Item No. Report of the Interim Director of Planning, Regeneration & Public Realm

Address: 1A HIGH STREET RUISLIP

Development: Installation of replacement signage to front and side of premises

LBH Ref Nos: 4628/ADV/2022/92

1 Front elevation

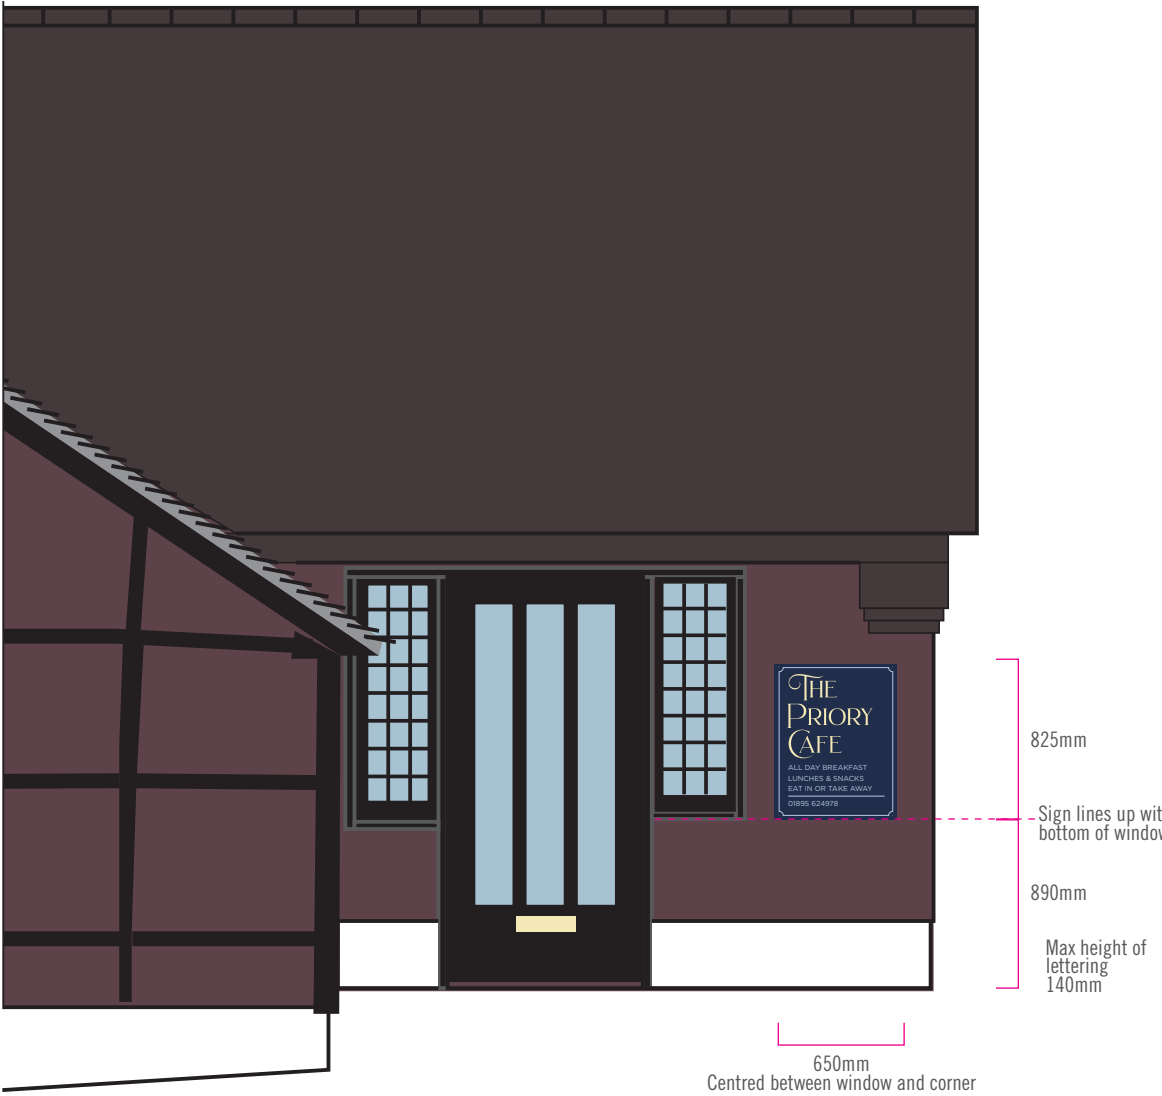
The proposal seeks to replace two existing signs for the cafe at number 1A. There is no objection to their replacement but there are concerns with the proposal. The sign plus chalkboard (Sign 1) to the front is too large and needs to be reduced in scale.

Following a reduction in the scale of the blackboard, the conservation officer raises no objection to the proposed signage which will have a traditional appearance that will complement the cafe of the listed building and preserve the character and appearance of the Ruislip Village Conservation Area.
